From: Martyn White
Sent: 11 December 2018 17:27
To: Planning.Responses
Cc: Anita Gardner
Subject: LU/310/18/PL

LU/310/18/PL

The application essentially involves two elements; a change of use and a large first floor extension which covers the entire ground floor area. The new floor area will introduce a new living accommodation.

DWG. NO / 021018 / TP.02

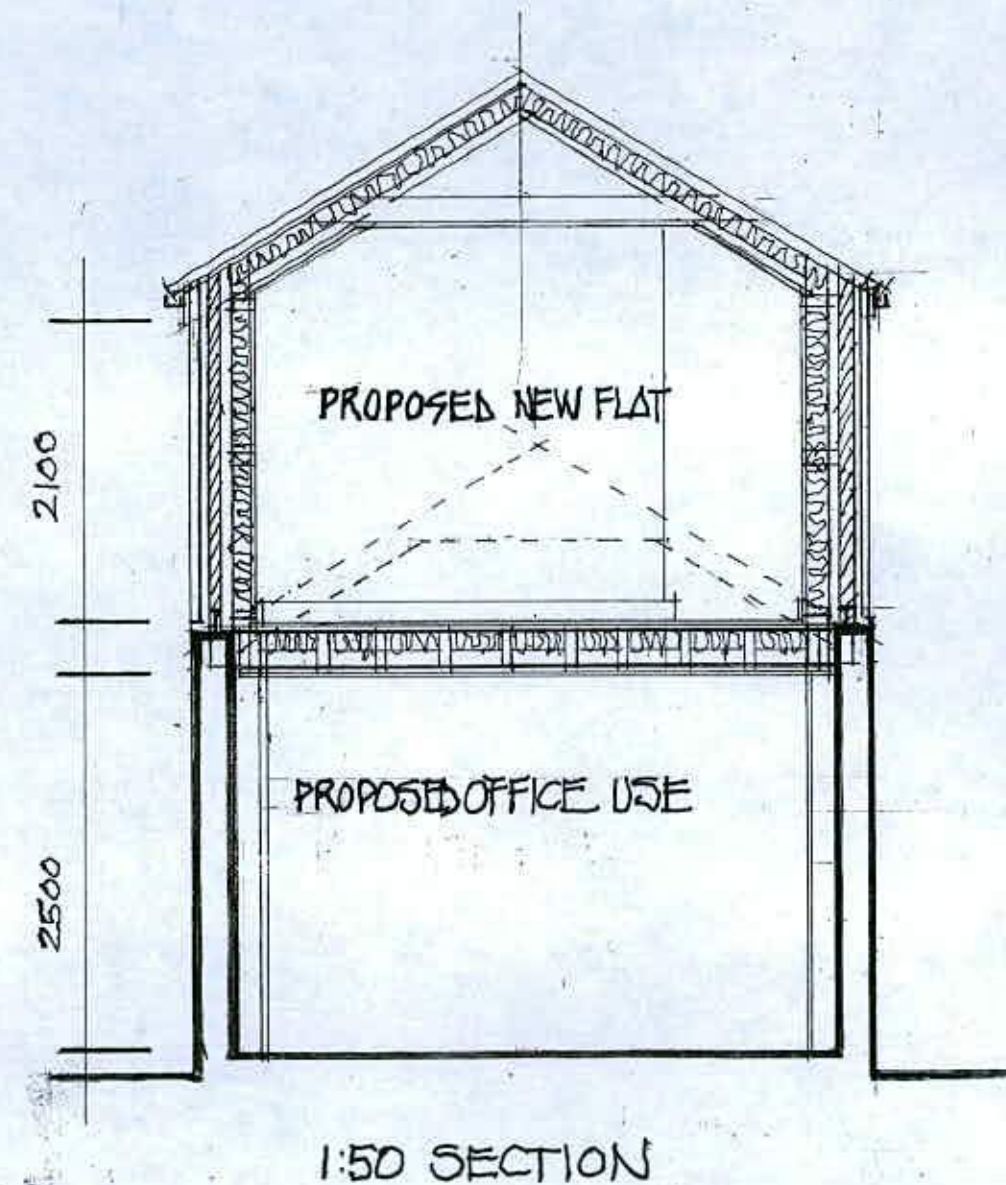
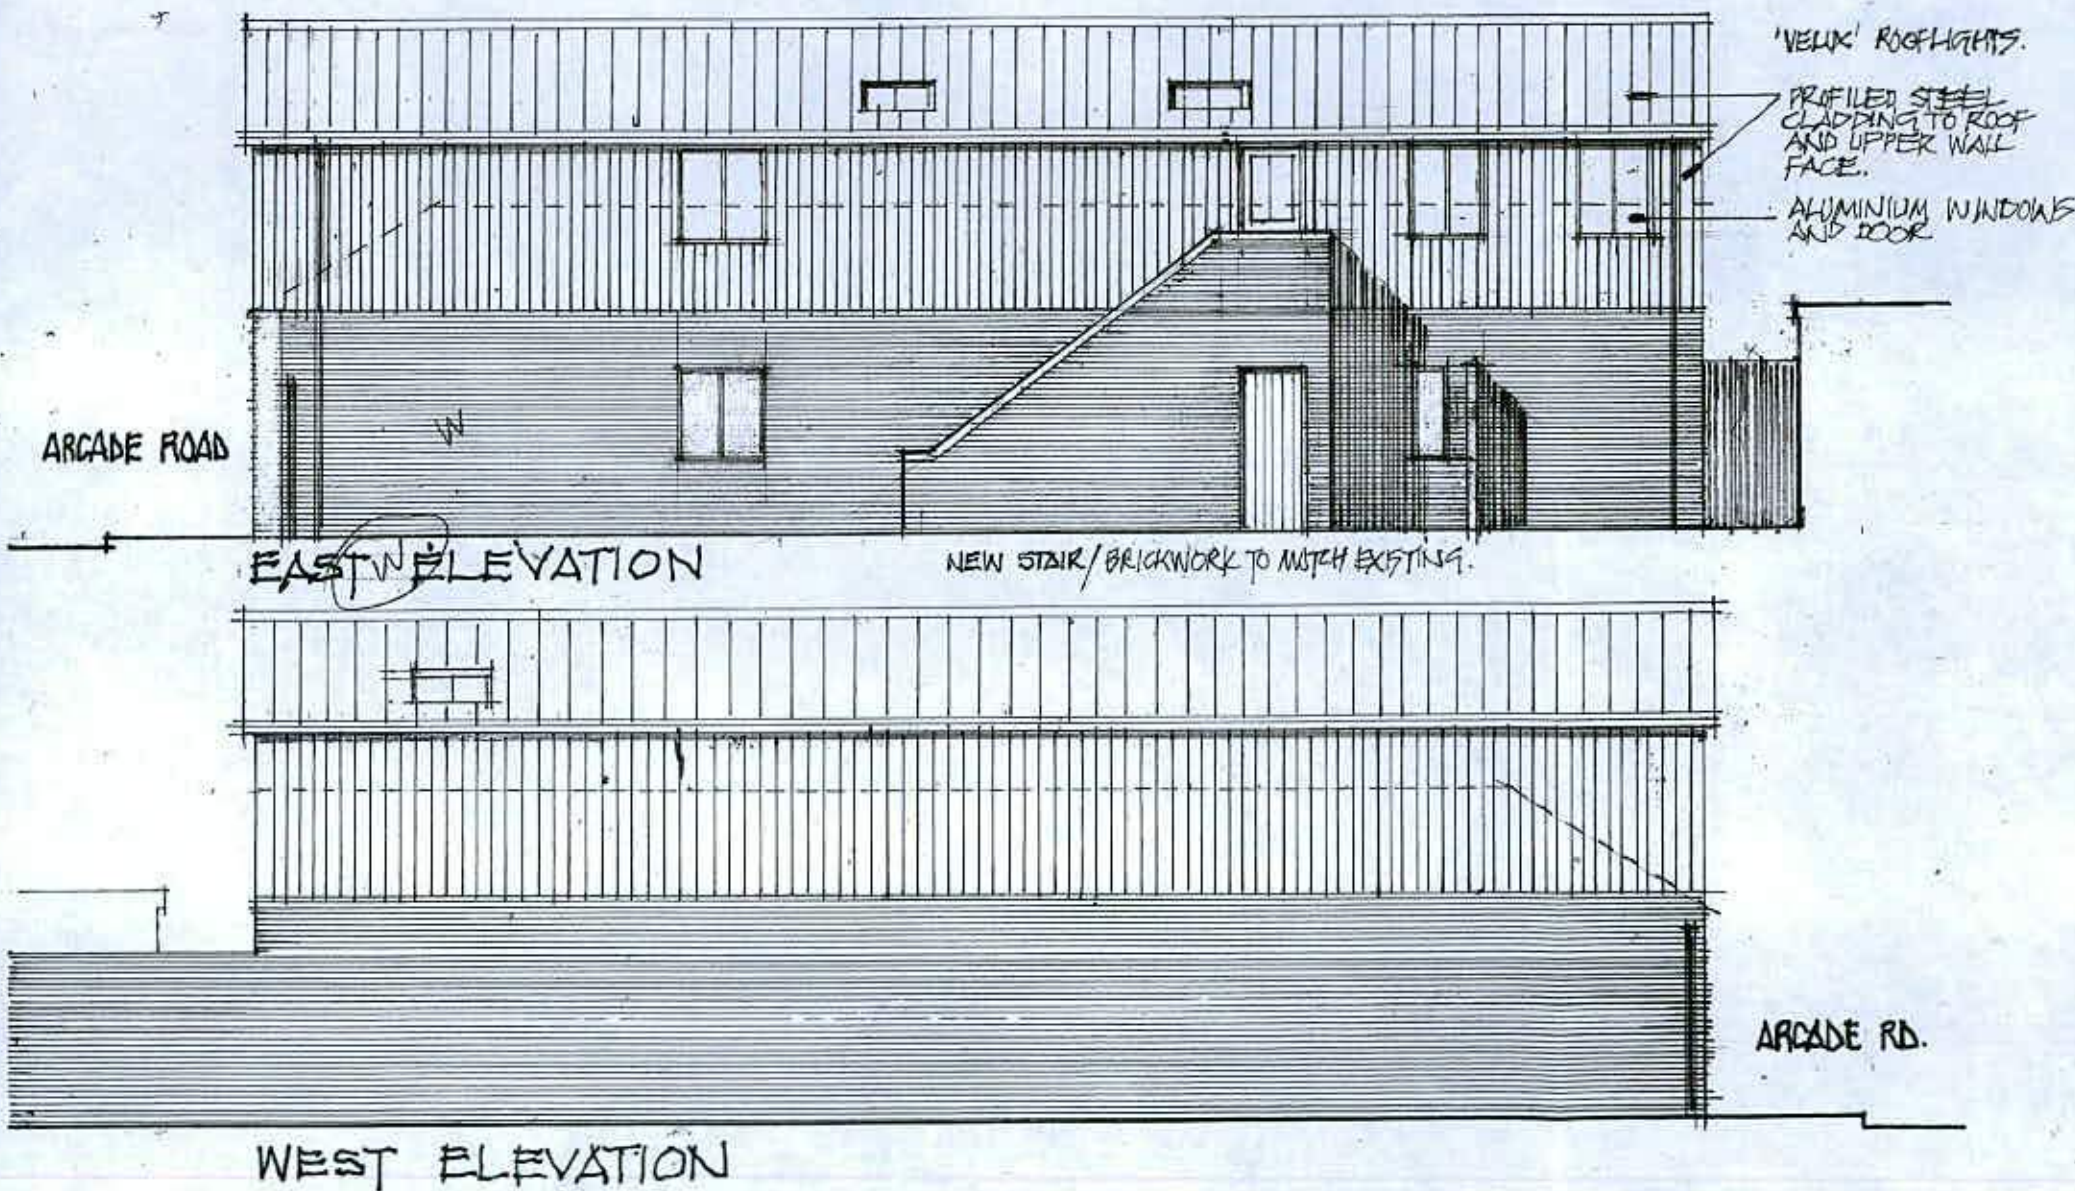
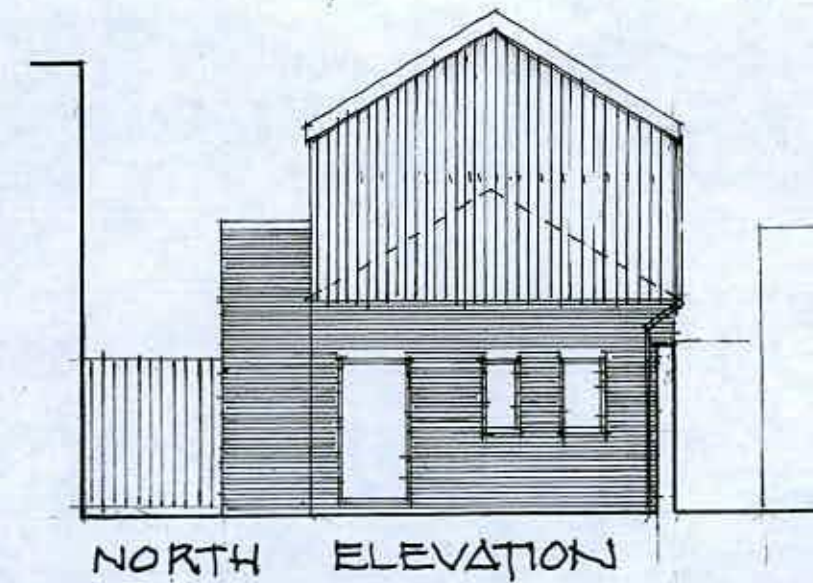
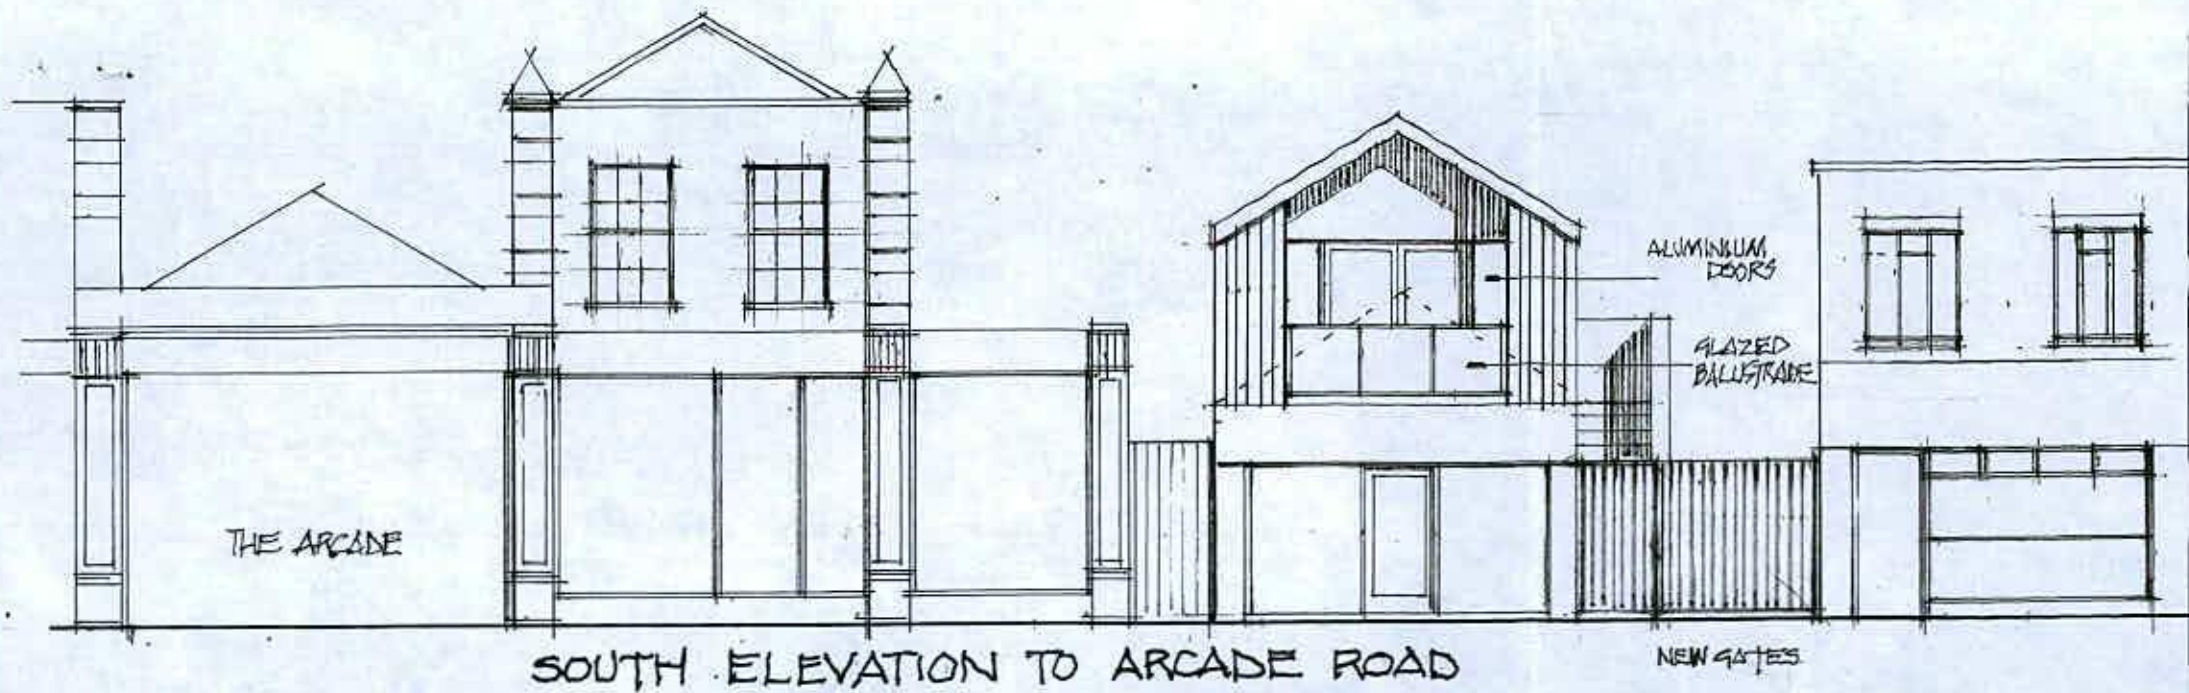
The extension is significant in size and would be visible on the street-scene. Whilst the concept of an additional floor on the building is not of undue concern (it could enhance the appearance of the building), the current proposal is problematic in that it is not clear how the proposed material will reflect the character of the buildings found in the local area.

Further, the design of the front elevation is such that it focuses on the proposed balcony. This appears to be the only balcony on the street-scene in the local area. Whilst this isn't necessary a concern in its own right, there is potential for the amount of glazing to mean that it would be out of character with the neighbouring building, and dominate this section of the street-scene.

The success of a scheme such as this will depend upon the quality of the materials used, and they will need to be agreed with the council prior to construction commencing.
